## MEMORANDUM

**TO:** Bill Needleman, Planner  
**FROM:** David Senus, P.E. & Ashley Auger, E.I.T.  
**DATE:** May 24, 2012  
**RE:** Jordan's Site Mixed Use Development, Level III Final Site Plan/Subdivision Application

Woodard & Curran has reviewed the Level III Final Site Plan/Subdivision Application for the Jordan's Site Mixed Use Development located at 203 Fore Street in Portland, Maine. The project consists of development of a five story mixed use condominium building with retail space, office space, and residential units.

**EROSION CONTROL PLAN**

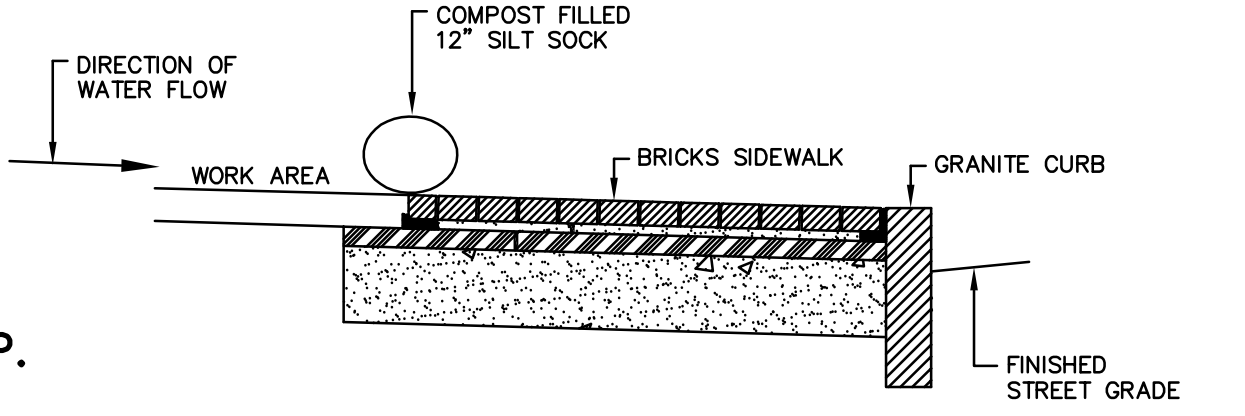
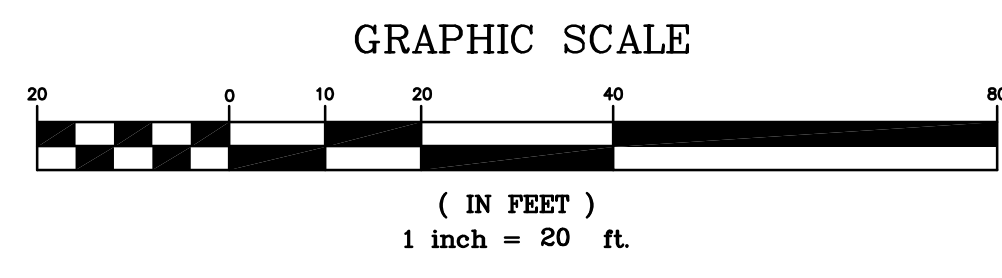
- a) Basic Standards: A detail should be provided for the compost filled silt sock noted on the erosion control plan. Notes should be provided on the plans to address erosion and sediment control requirements, inspection and maintenance requirements, and good housekeeping practices in accordance with Appendix A, B, & C of MaineDEP Chapter 500.

Stormwater Modeling – Post-Development Model

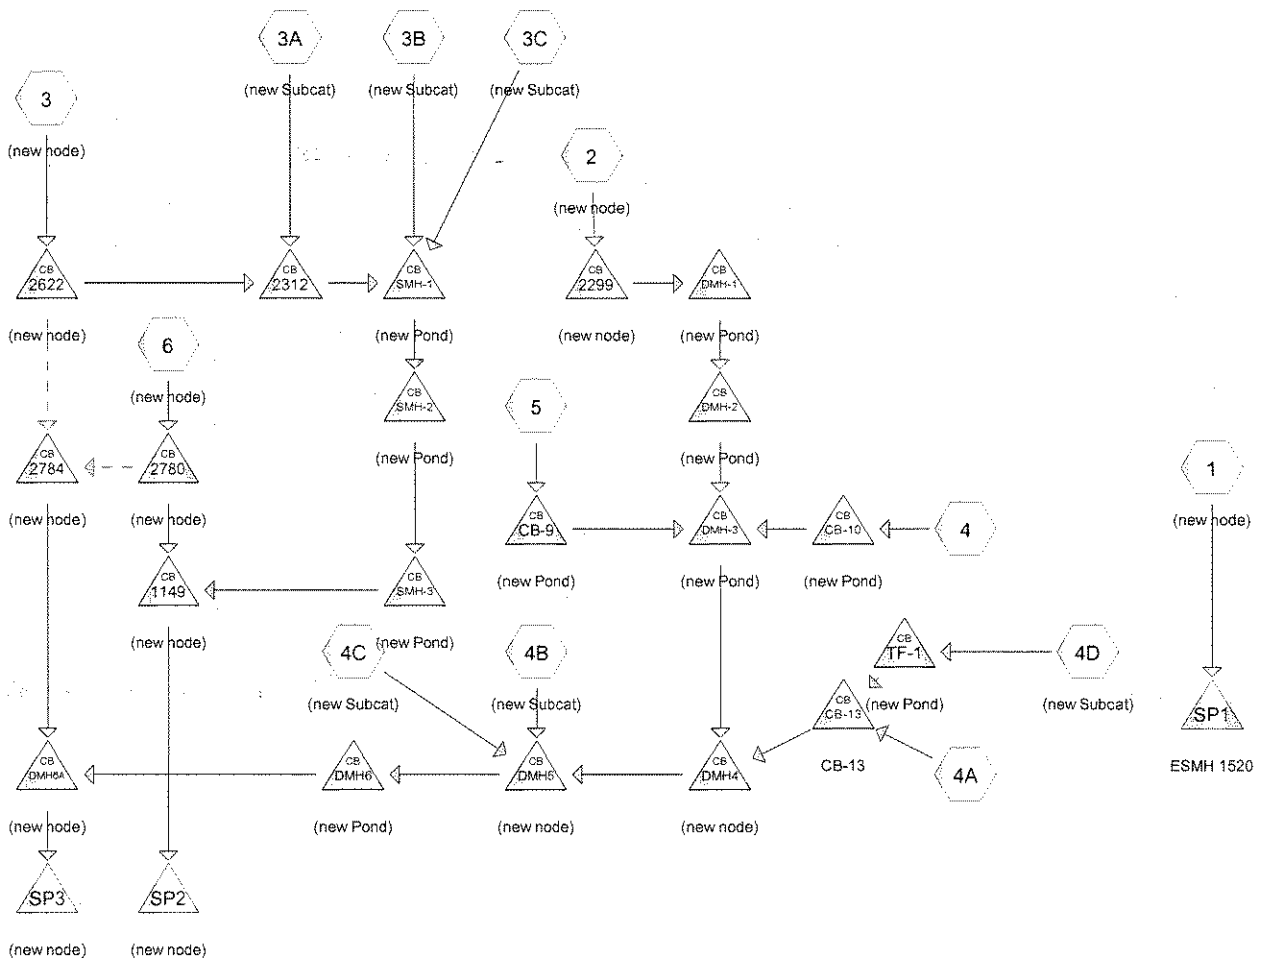
- c) Flooding Standard: The Applicant has submitted a detailed stormwater model indicating that post-development runoff rates for the project will have minor increases from the pre-development conditions during certain storm events. The model is noted to be an addendum to the Stormwater Management Plan prepared by Sebago Technics for the site, dated February 16, 2010 (and approved under an earlier Site Plan review). It is our understanding that much of the stormwater runoff from the project site will be routed to a separated storm drain pipe in Franklin Arterial. As such, we support a waiver from the flooding standard for these minor increases in peak runoff rates from the site.
